An
Coimisiún
Pleanála

Commission Order
ABP-320327-24

Planning Authority: Wicklow County Council

Planning Register Reference Number: EX53/2024

CLIENT	Tondo Ltd.				DATE	19-10-2022
JOB TITLE	Development at Kippure Estate					
LOCATION	Manor Kilbride, Blessington, Co. Wicklow					
STATUS	Pre-Planning		CHECKED	AB	SCALE	1:100@A1
DRAWN	NF		APPROVED	AB		
DRAWING No.		DRAWING TITLE			REVISION	
PL-0206-01-KE		Structure 02 and Structure 06			D

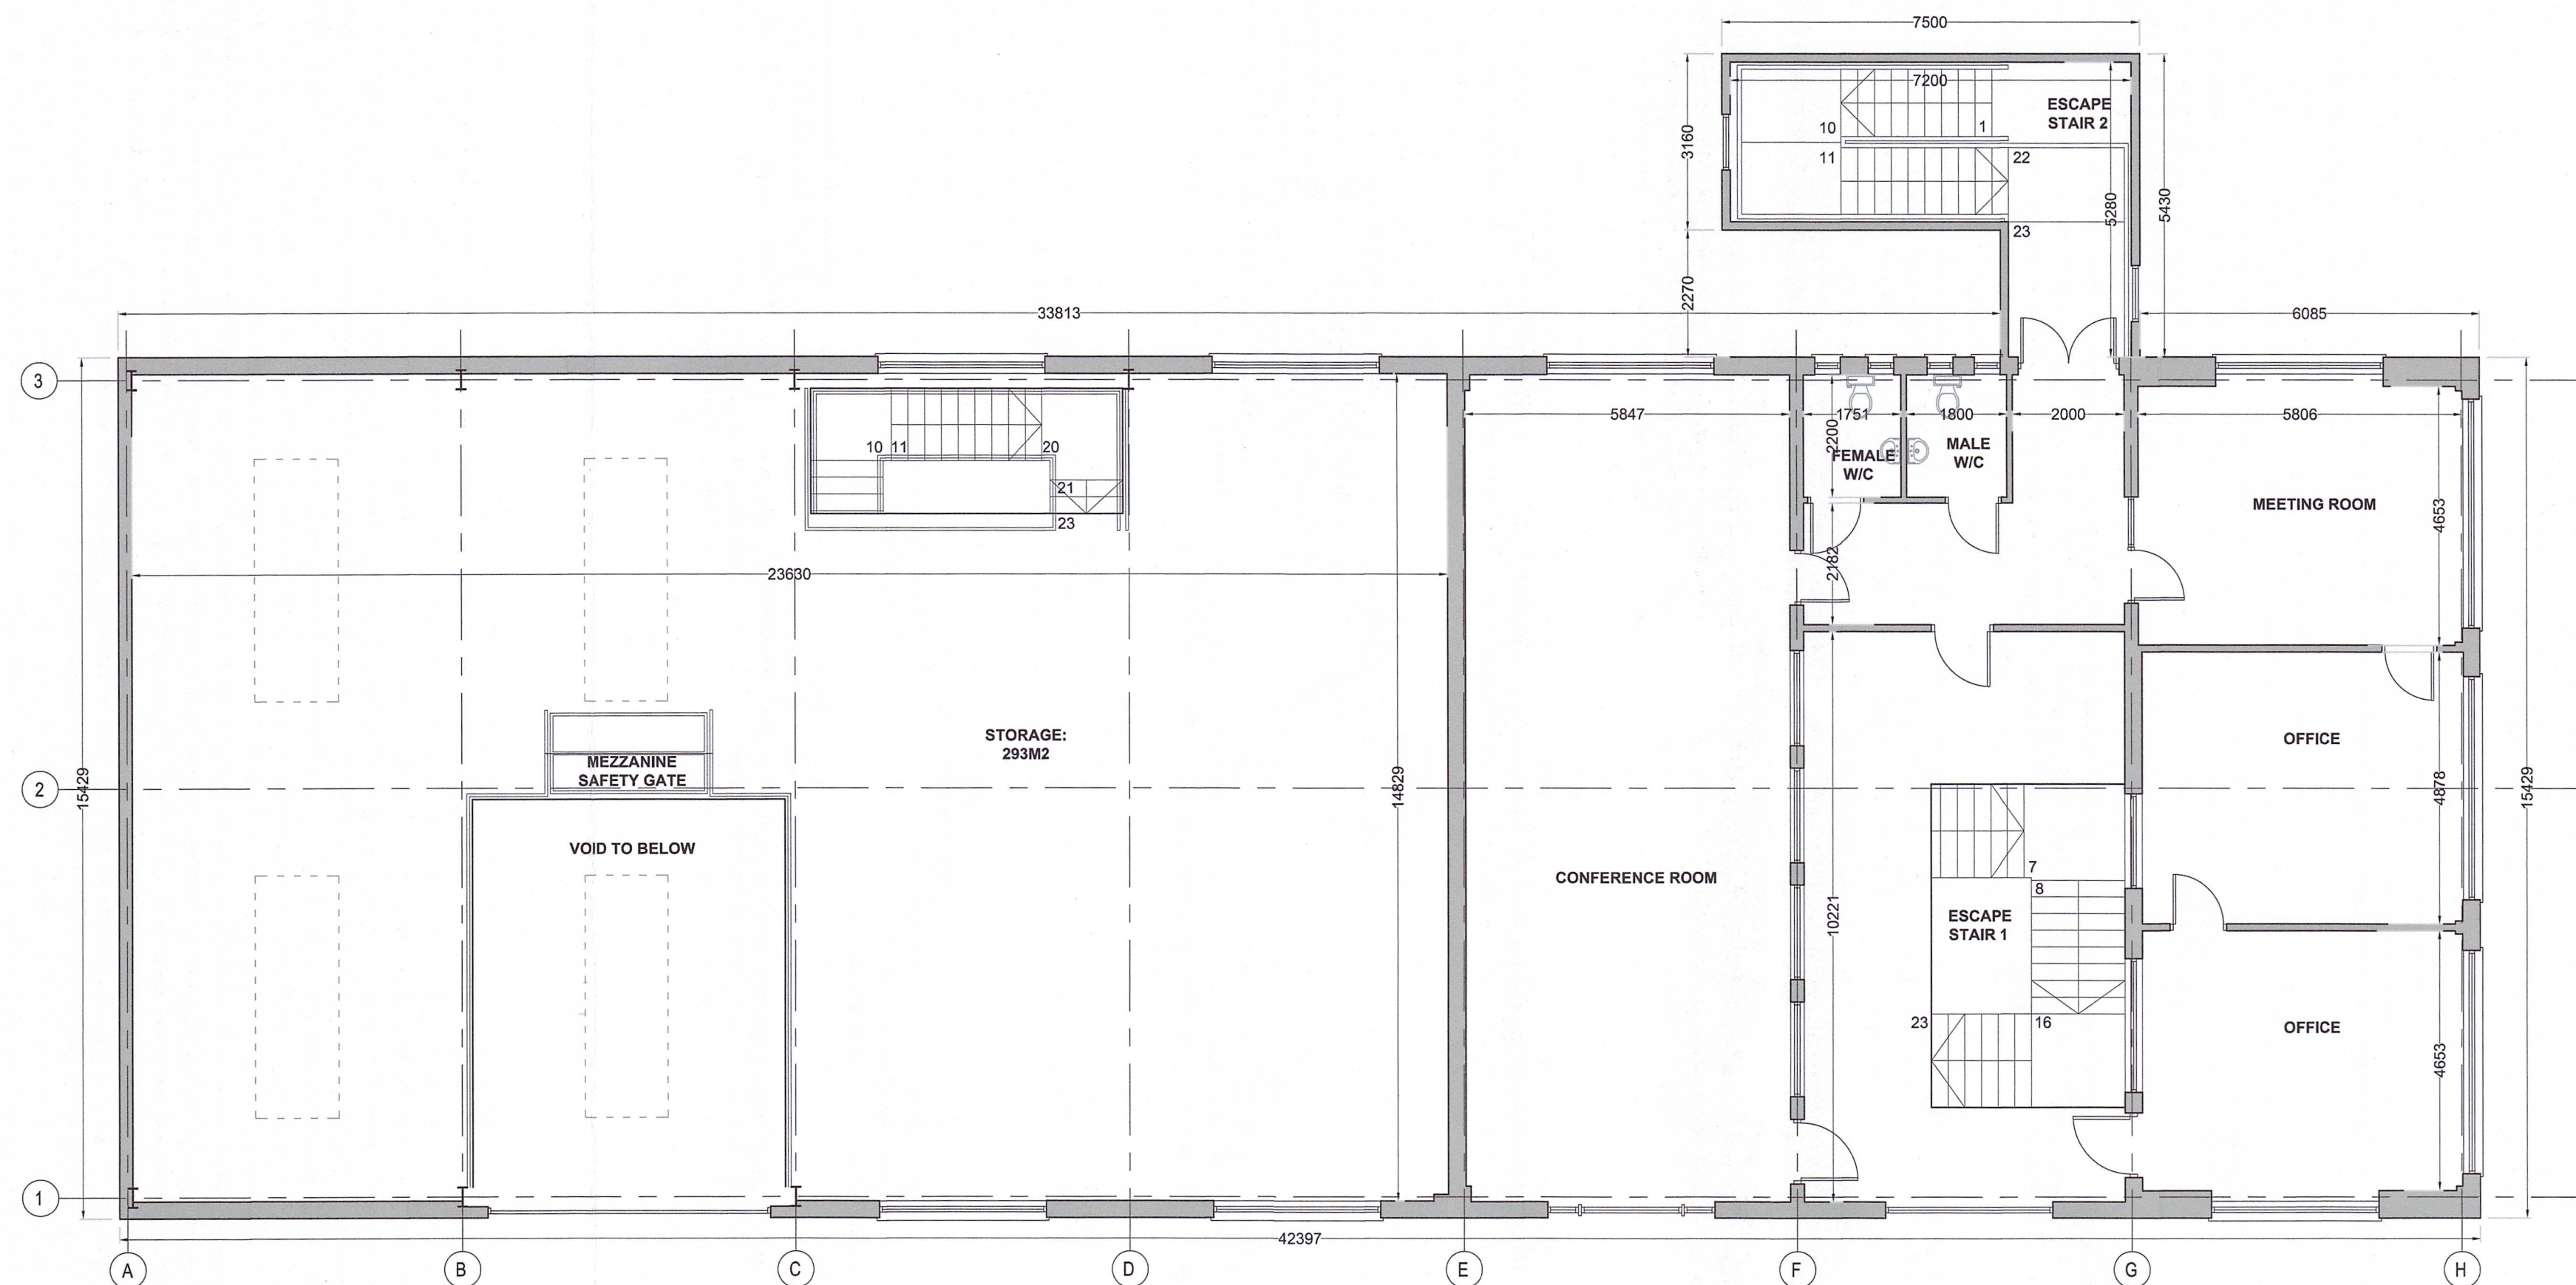
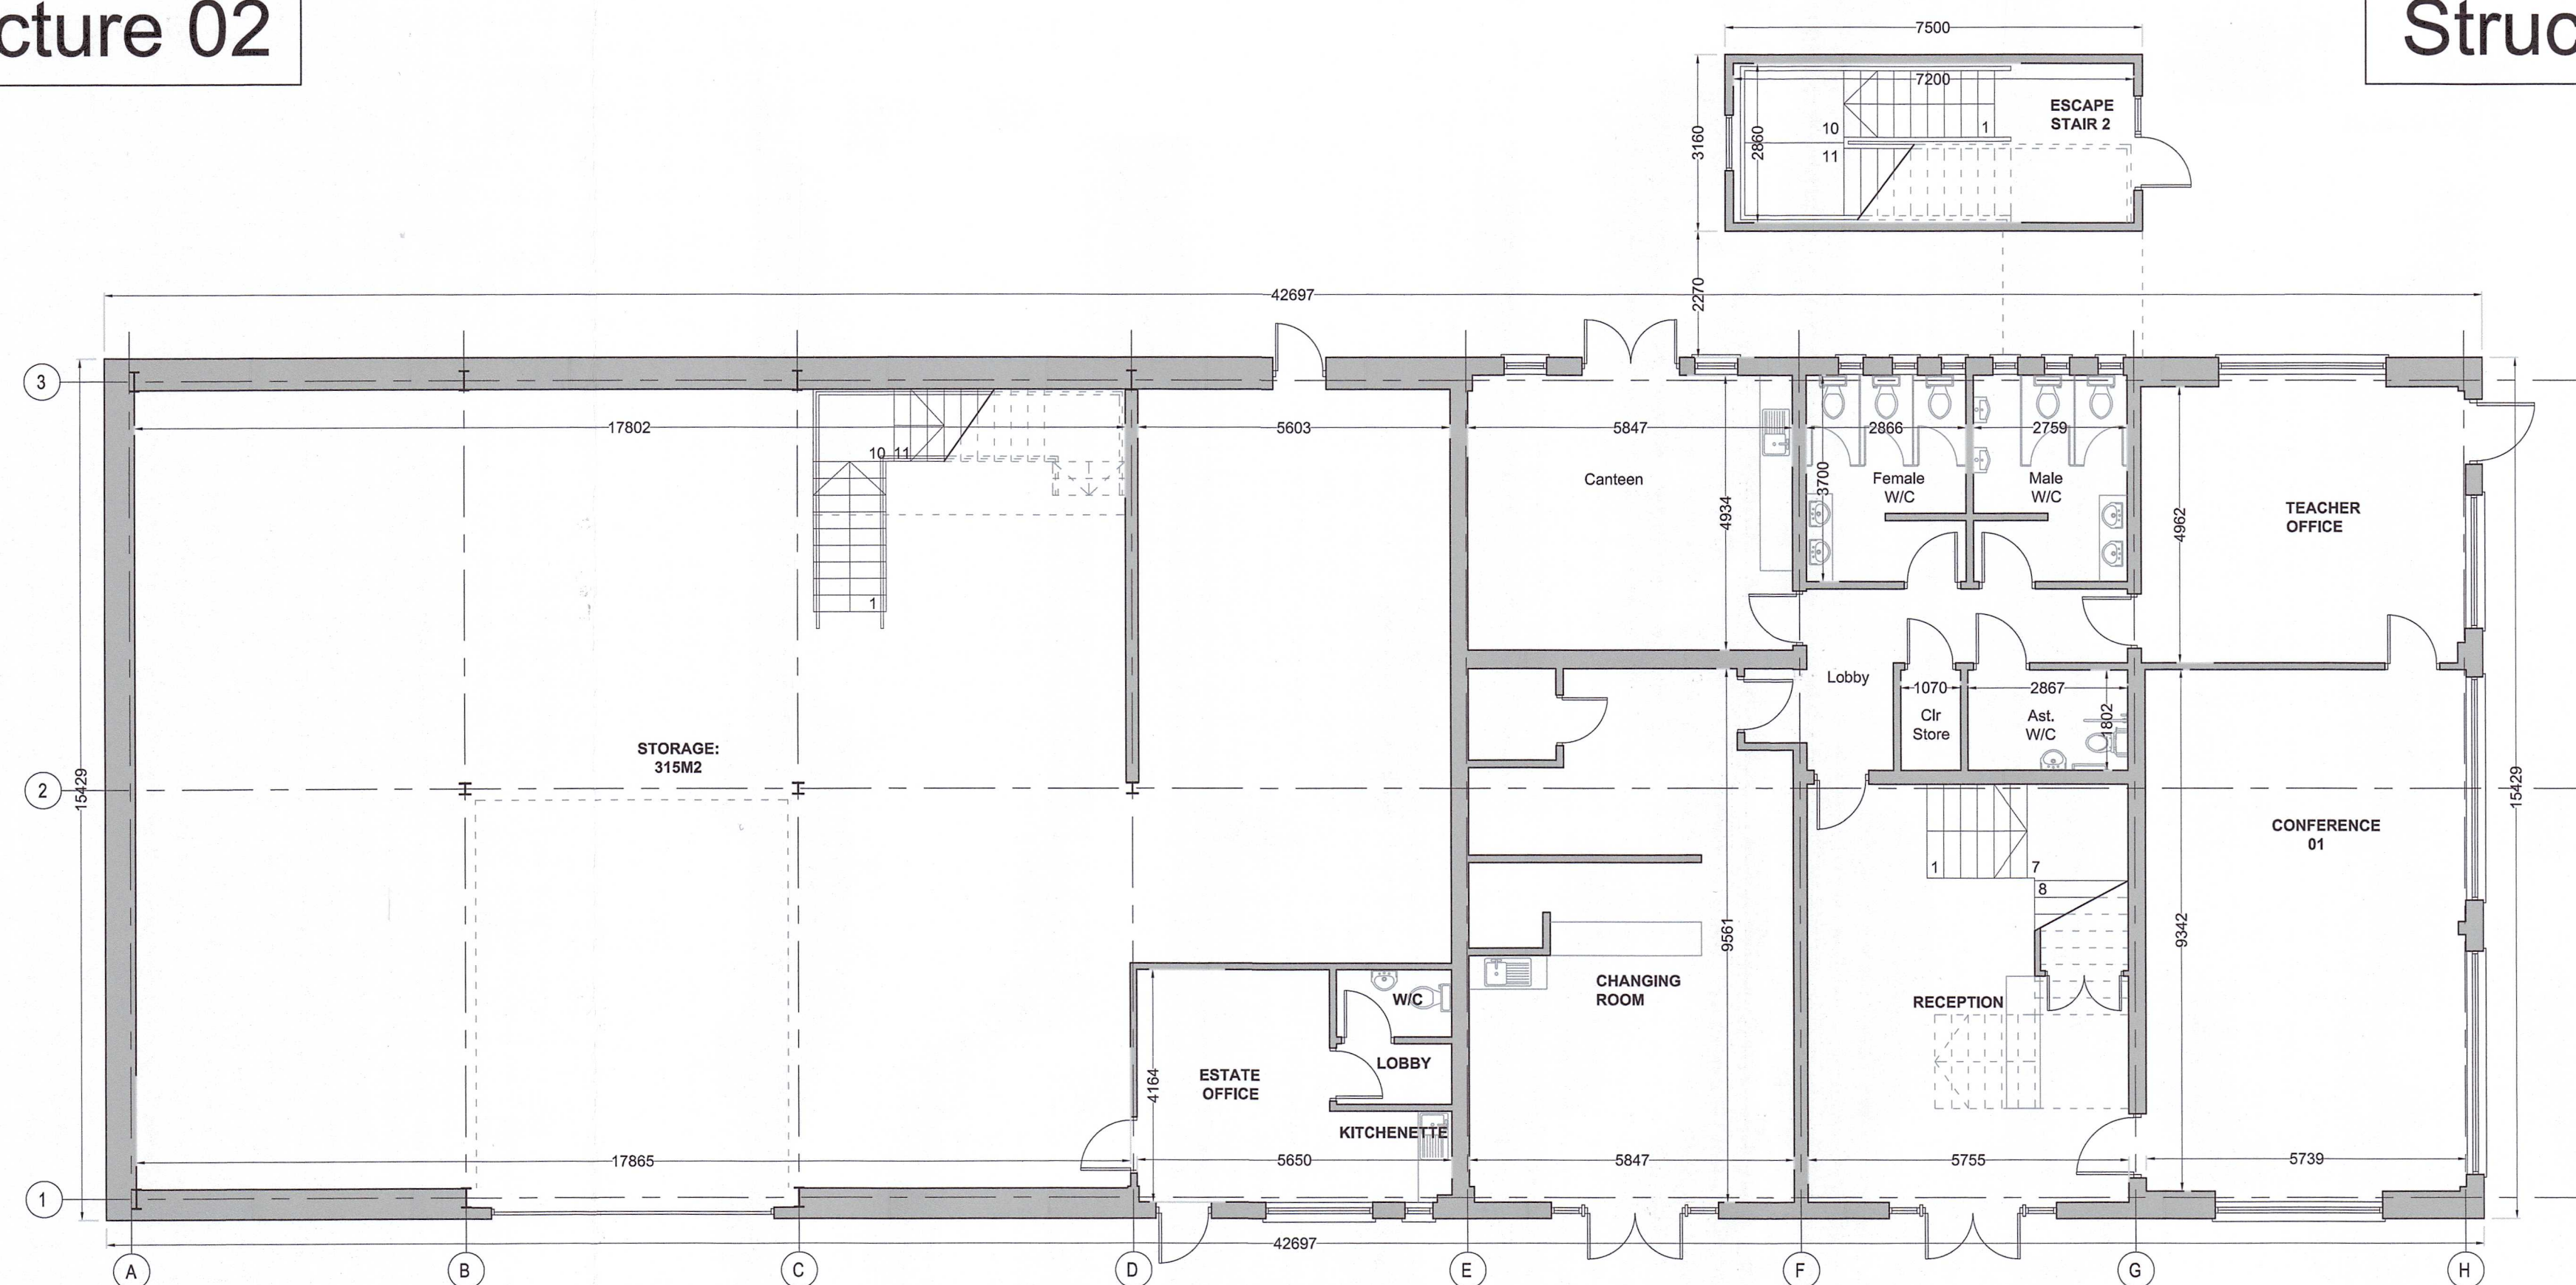
- (b) Structure Number 2: Semi-detached agricultural storage facility does not fall within the scope of Class 9 of Part 3 of Schedule 2 of the Planning and Development Regulations 2001, as amended, as the use of the structure for agriculture or forestry has not been adequately demonstrated. The structure has a gross floor area that exceeds the 300-square-metre limitation and the aggregate gross floor space of the structure, with other such structures within 100 metres, exceeds the 900-square-metre limitation. Therefore, this structure does not constitute exempted development.

- (f) Structure Number 6: Former agricultural building, now used to accommodate protected persons, does not fall within the scope of Class 9 of Part 3 of Schedule 2 of the Planning and Development Regulations 2001, as amended, as it has a gross floor area that exceeds the 300-square-metre limitation. In addition, the aggregate gross floor space of the structure, with other such structures within 100 metres, exceeds the 900-square-metre limitation. Therefore, this structure does not constitute exempted development. This structure does not fall within the scope of Class 14(h), (i) or (j), or Class 20F of Part 1 of Schedule 2 of the Planning and Development Regulations 2001, as amended, as there is no exemption for a change of use from agriculture to accommodation or an emergency reception and orientation centre for protected persons.

In addition, the referrer has not demonstrated that this structure was constructed on behalf of the Minister for Children, Equality, Disability, Integration and Youth. There is no evidence that Structure Number 6 was carried out in accordance with the provisions of the European Union (Planning and Development) (Displaced Persons from Ukraine Temporary Protection) Regulations 2022 (S.I. Number 306/2022). There is no evidence that the structure is related to accommodation for displaced persons, given the definition of such persons as set out in Annex 2 of the Council Implementing Decision (EU) 2022/382. Therefore, this structure does not constitute exempted development.
